## DRAINAGE AND TRANSPORTATION INFORMATION SHEET

**Project Title:** 2350 Alamo Road **Building Permit #** \_\_\_\_\_ **Hydrology File #** \_\_\_\_\_

**RE: 2350 ALAMO ROAD SW  
TRAFFIC CIRCULATION LAYOUT  
RESPONSE TO COMMENT**

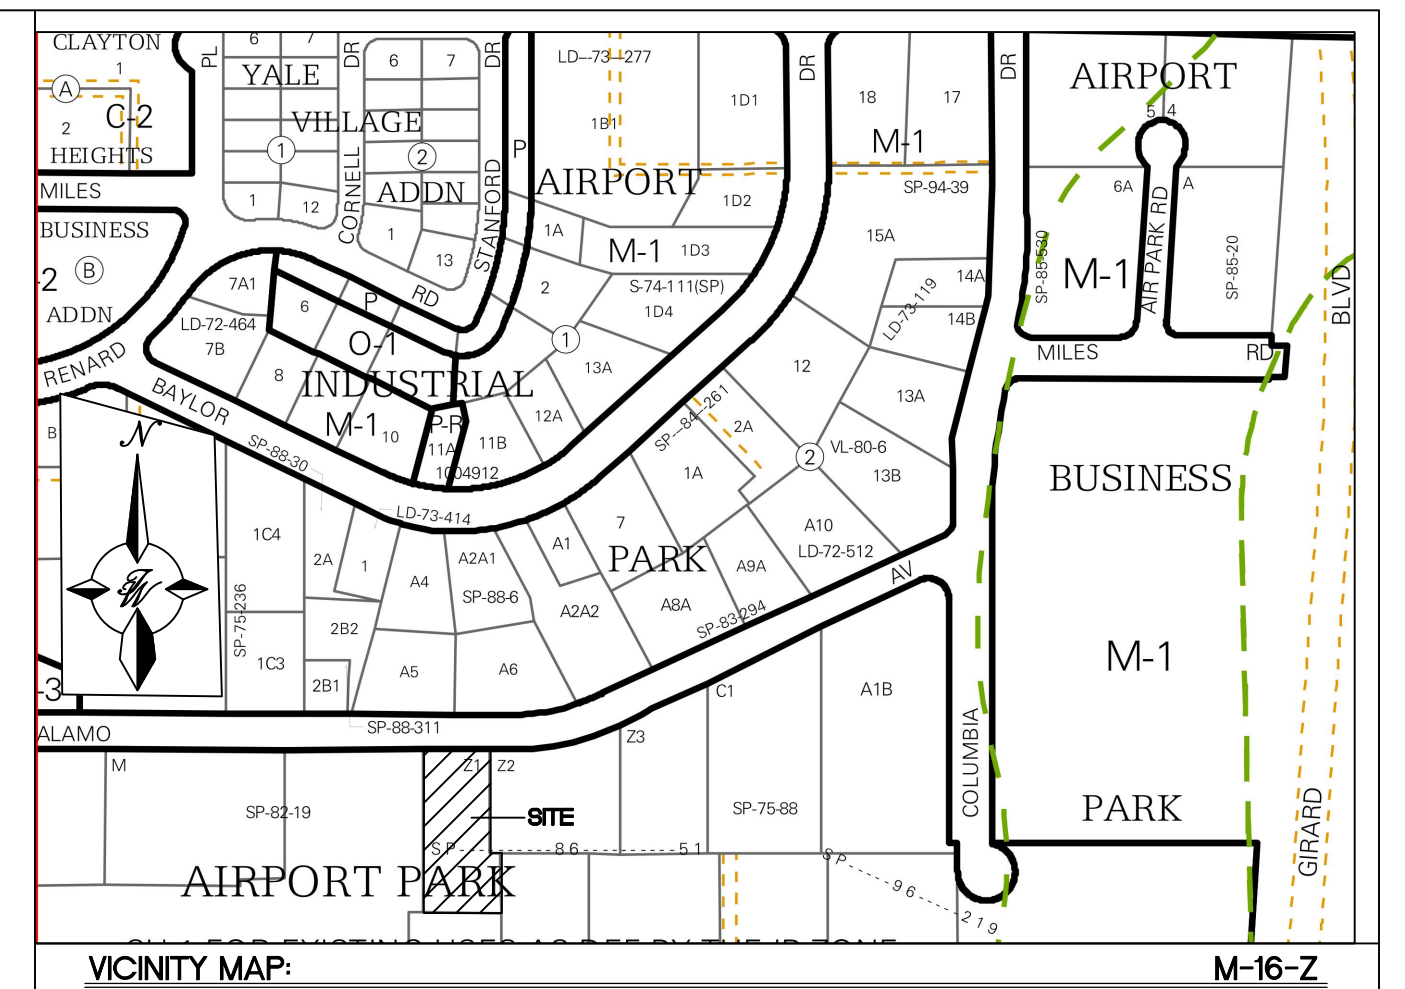
4. Please show on the site plan the distance between both site accesses.  
**Response: See updated traffic circulation plan.**
5. Details sheet C2.1 is missing.

19. Please show on the site plan the clear sight distance triangle exhibit.

**Response: See updated traffic circulation plan.**

6" PRIVATE CURB & GUTTER

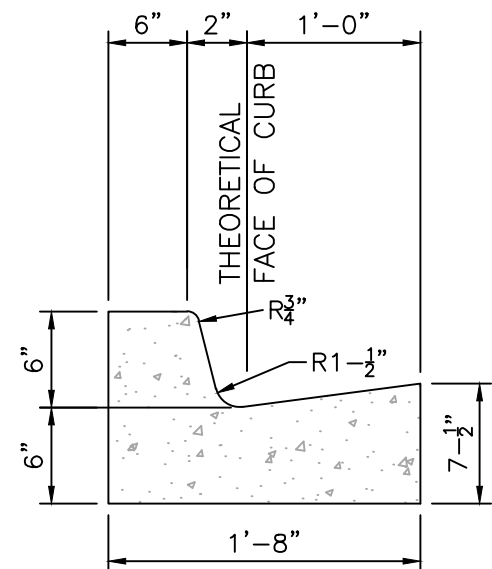
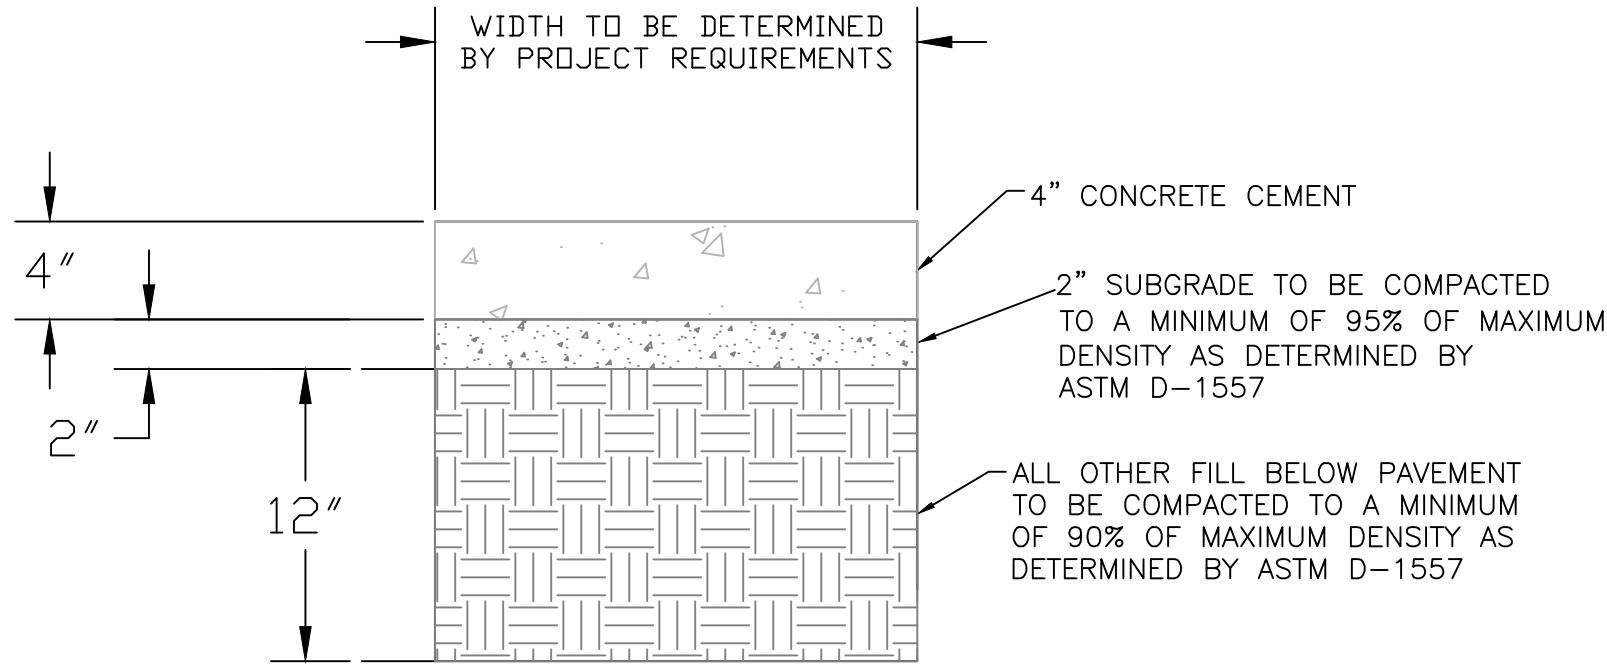
15. Curbing should be installed to delineate landscape, parking, and pedestrian ways and identify points of access. Please call out detail and location of barrier curb.

**Response: See updated traffic circulation plan.**

PARALLEL CURB HC RAMP

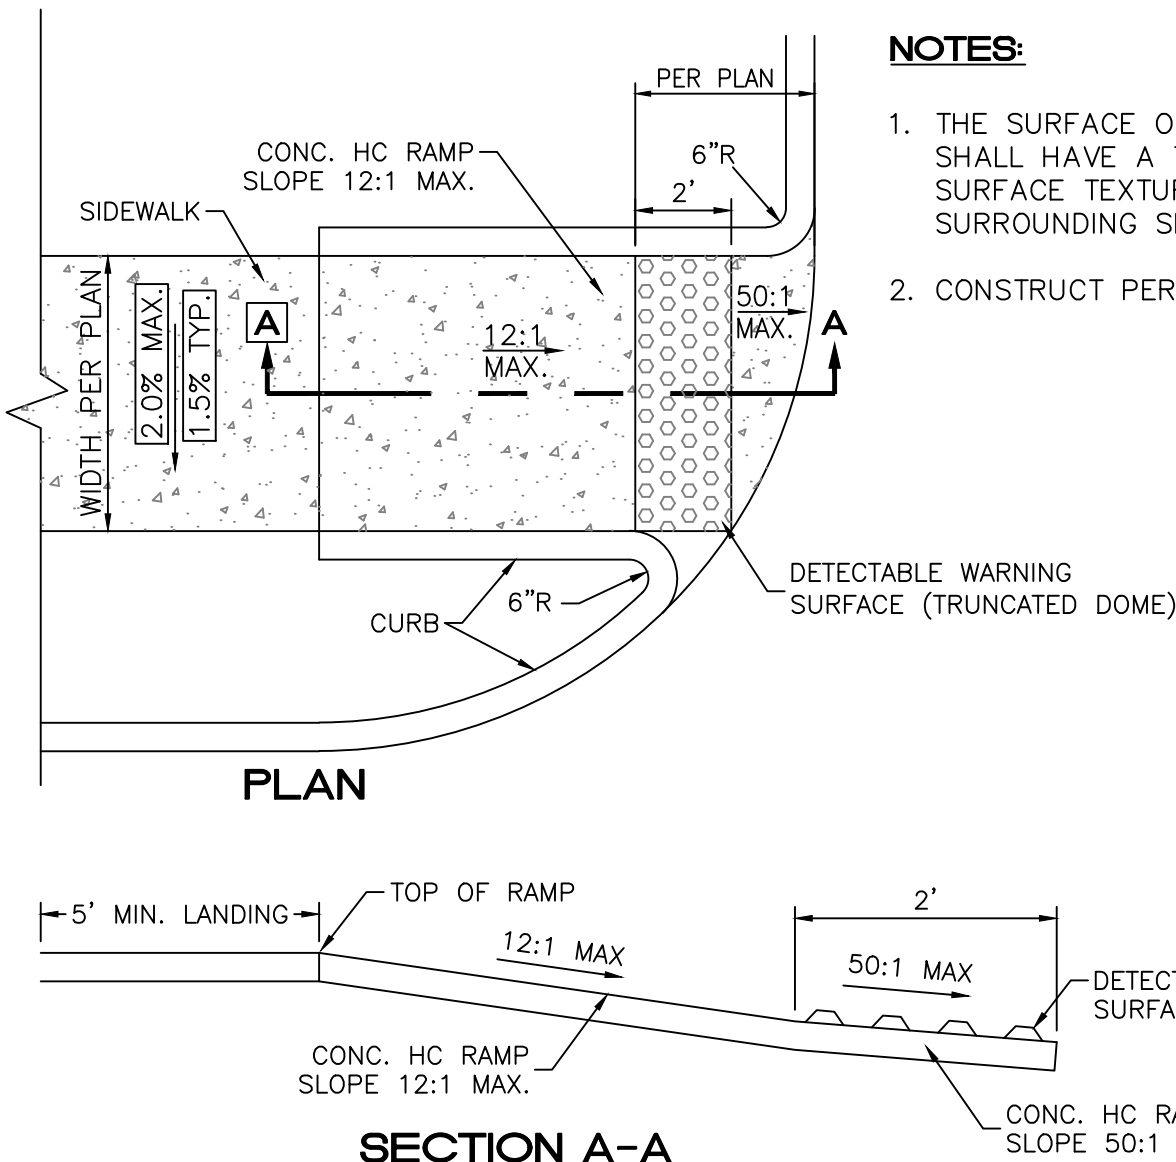
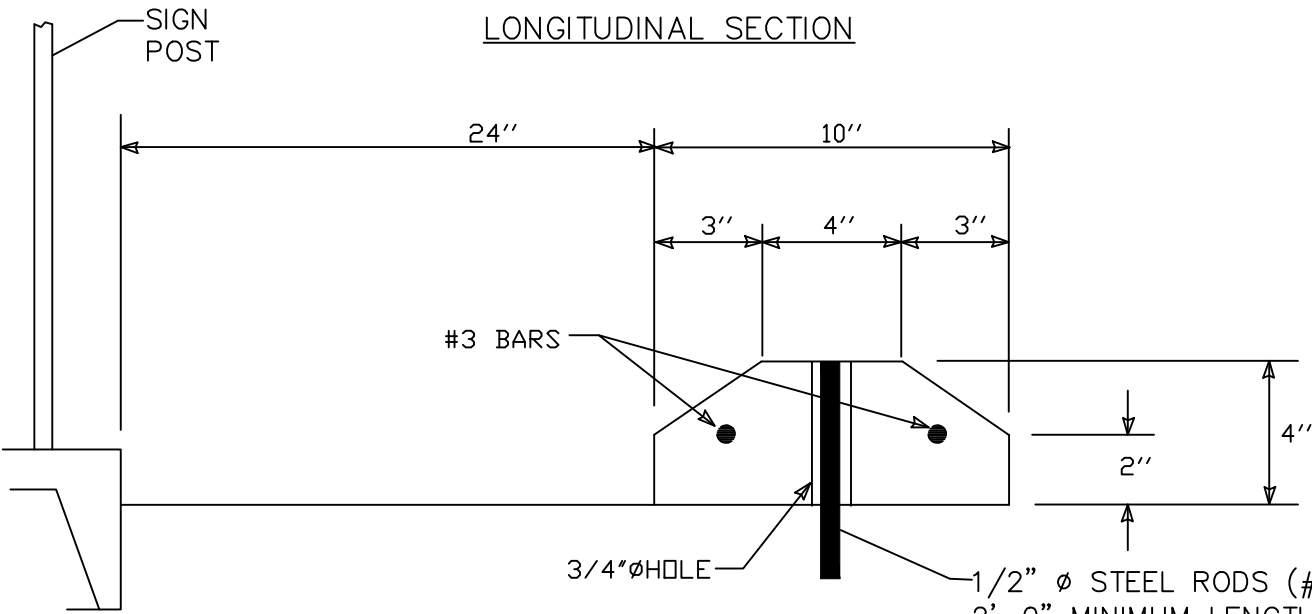
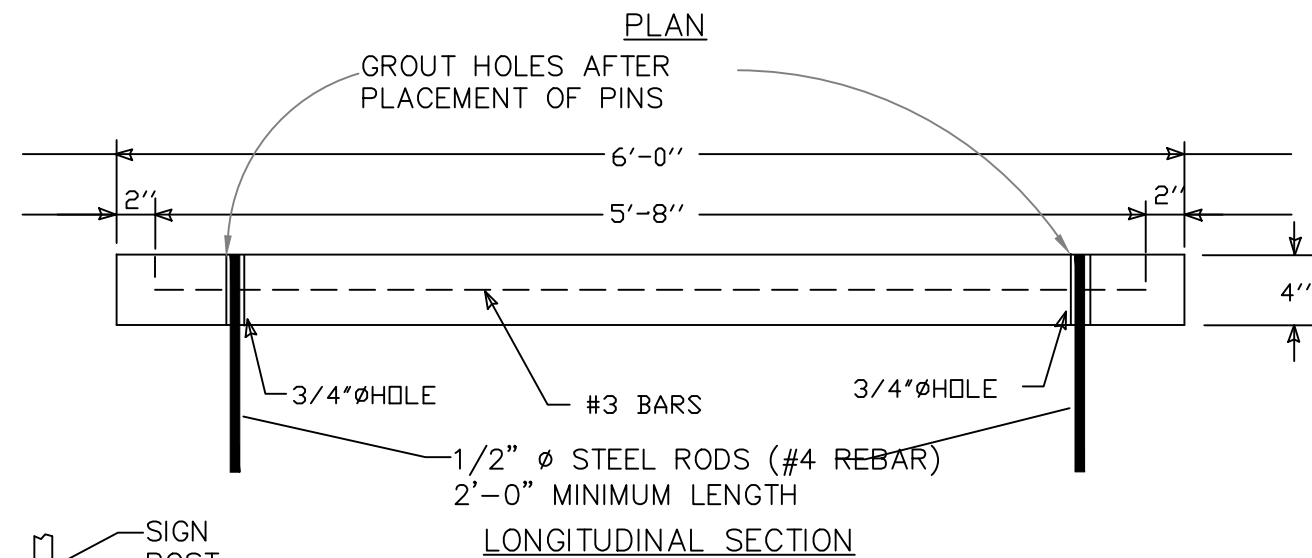
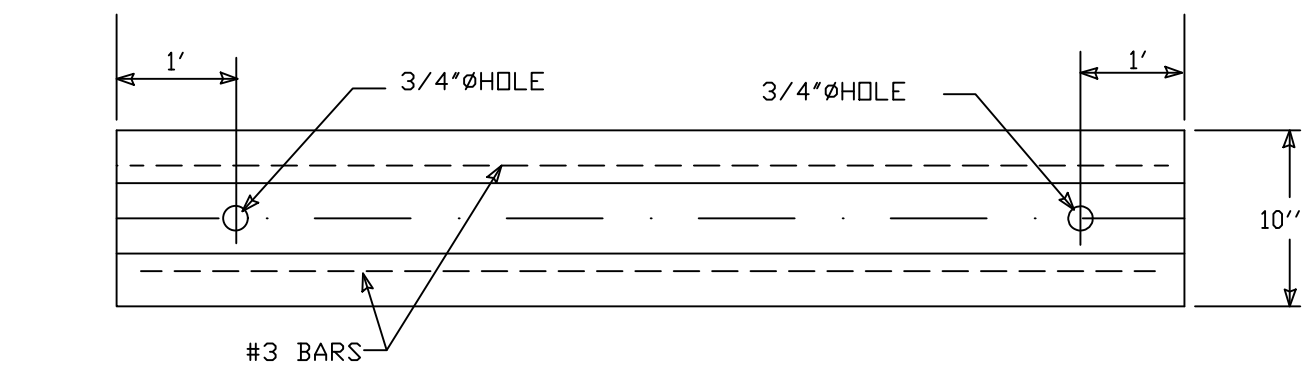
**Response: Detail sheets added to submittal.**
6. Please define ADA pathway by labeling of ramps or flush.  
**Response: See updated keyed notes 9 and 10.**

HC PARKING DETAIL

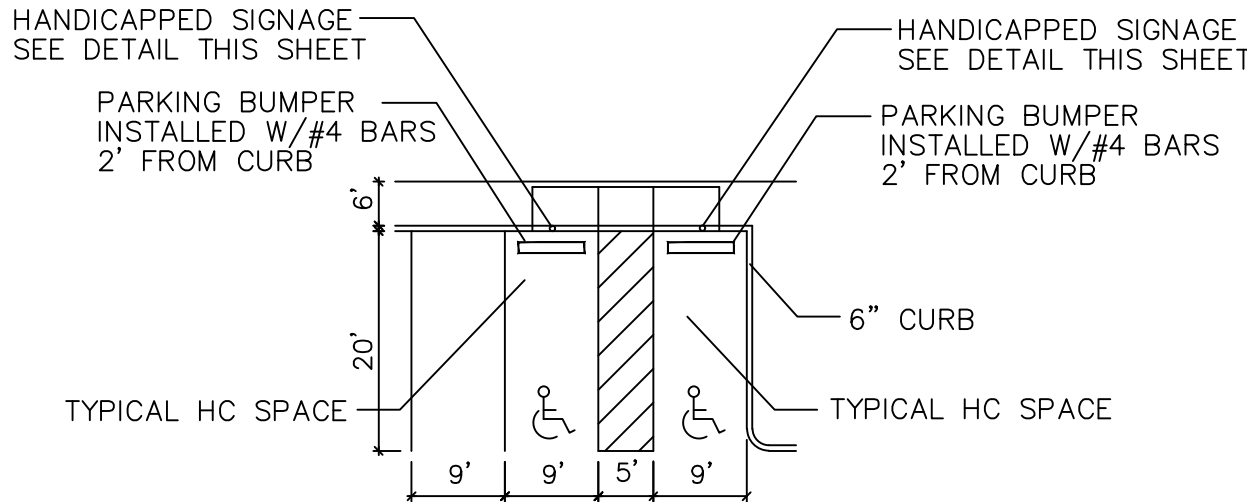
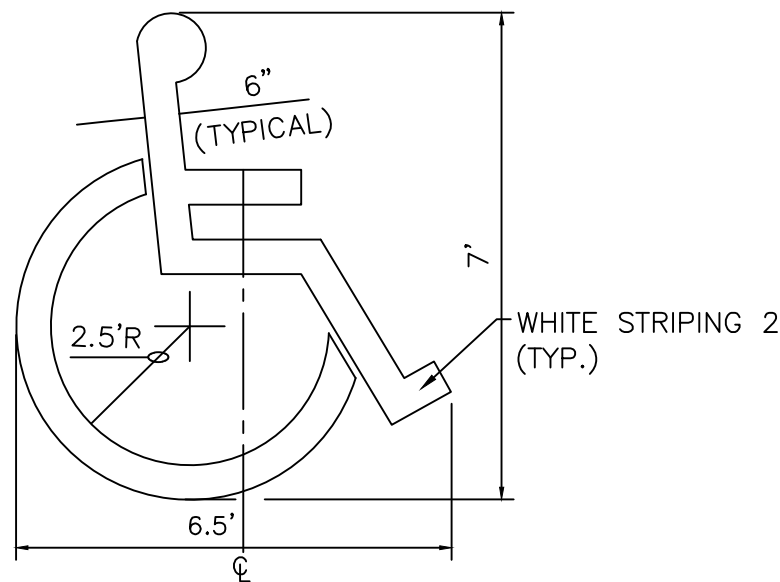
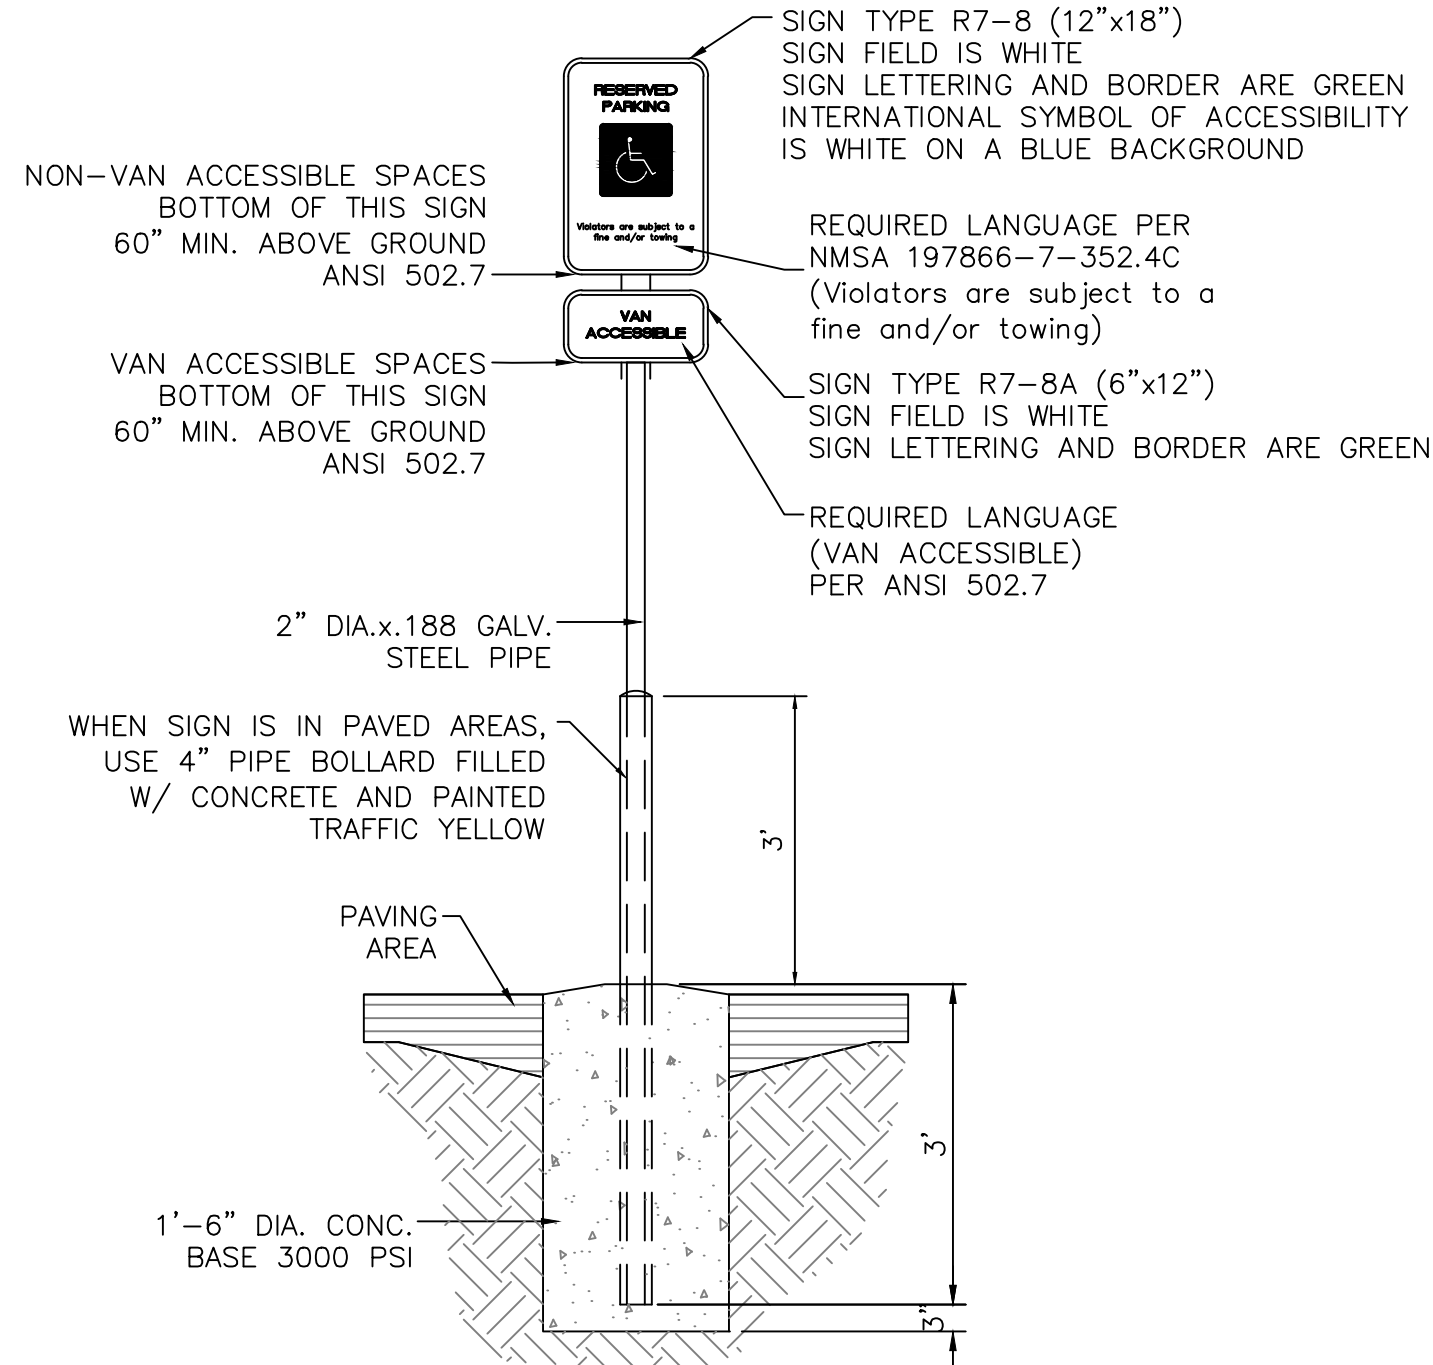
9. The ADA access aisles shall have the words **"NO PARKING"** in capital letters, each of which shall be at least one foot high and at least two inches wide, placed at the rear of the parking space so as to be close to where an adjacent vehicle's rear tire would be placed. (66-1-4.1.B NMSA 1978)

**Response: See detail sheet C2.1.**
